DOC20/604489-13

Proposed New Berrima Brickworks Facility, 416 and 524 Berrima Road, Moss Vale (SSD-10422)

I refer to your email of 27 July 2020 to the Environment Protection Authority (EPA) inviting comments on the Environmental Impact Statement (EIS) for the above project, including advice on recommended conditions. The project is proposed to replace the existing Bowral brickworks plant.

Figure 1: Extent of Exceedance of the 24-hour average HF Concentrations on Impact Area 2 (Represented by the Solid Orange Coloured Area)

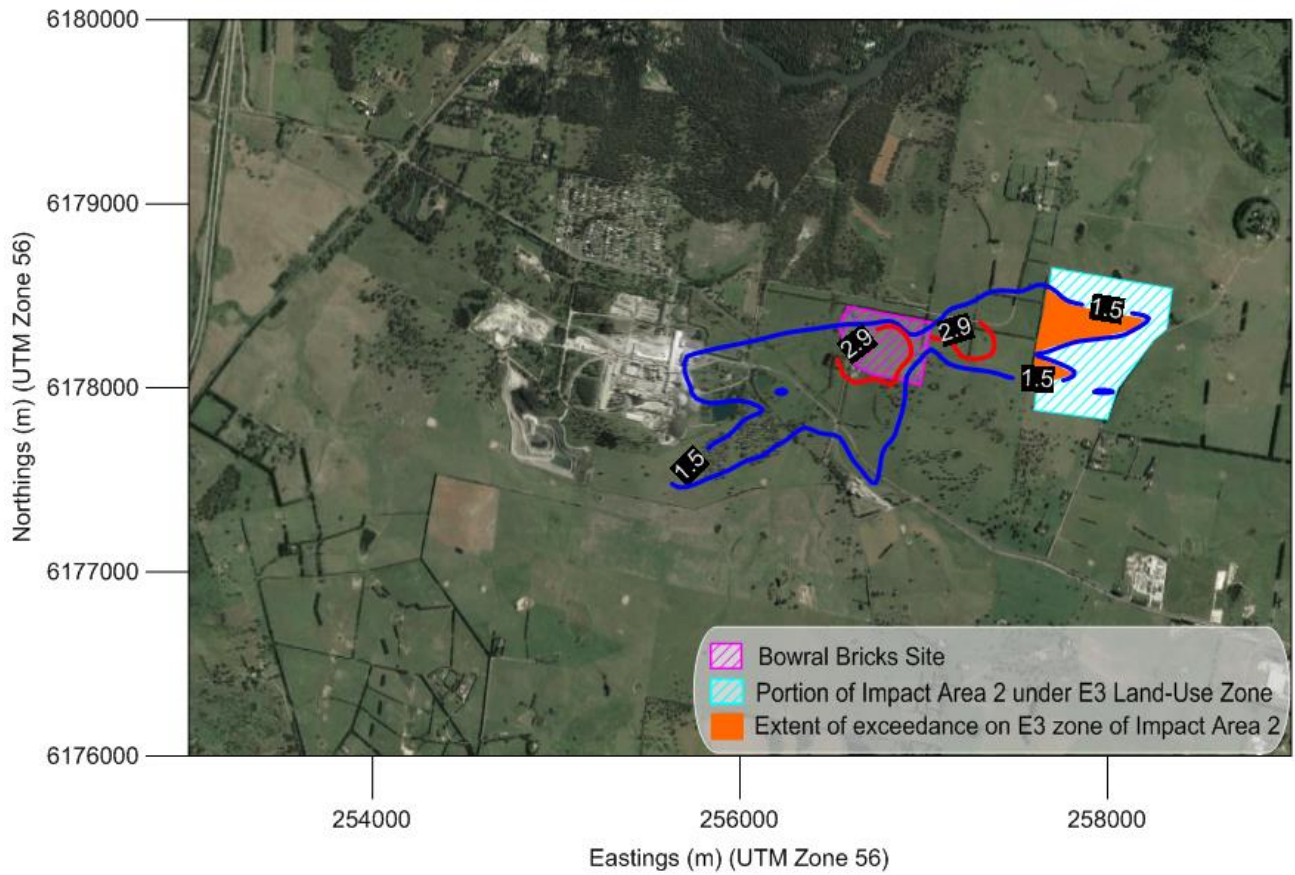
Hydrogen fluoride (HF) impacts on sensitive land has not been adequately assessed

6. The HF impact assessment criteria (IAC) from the Approved Methods for Modelling and Assessment of Air Pollutants in NSW (Approved Methods) for “general land use” has been used in the AQIA. The AQIA has predicted that offsite HF concentrations at all identified receptors are below this IAC. A more stringent IAC exists for specialised land use, which includes all areas with vegetation sensitive to fluoride.

Section 6.4 of the AQIA states “*At the time of preparing this assessment, it is unknown whether the land-use surrounding the proposed facility comes under the specialised land-use category. However, as per the Wingecarribee Local Environmental Plan 2010 – Land Zoning Map LZN_007C (refer Figure 4), the proposed facility is located in the General Industrial (IN1), with the Boral Cement Plant in the Heavy Industrial (IN3) zone and the Austral Bricks Quarry in the E3 – Environmental Management zone*”.

To the north of the site there is land zoned as E2 Environmental Conservation and E3 Environmental Management. Additionally, wineries are in the general vicinity of the proposed facility and grapes are a sensitive vegetation type.

The AQIA has not adequately demonstrated that the general land use IAC is appropriate. For determination of HF impacts, the Approved Methods specifies assessment criteria for general land-use and for specialised land-use which is applicable to all areas with vegetation sensitive to fluoride.

The EPA requests that the proponent provide a detailed land use and vegetation assessment to evaluate current and potential future land uses and vegetation that may be sensitive to fluoride.
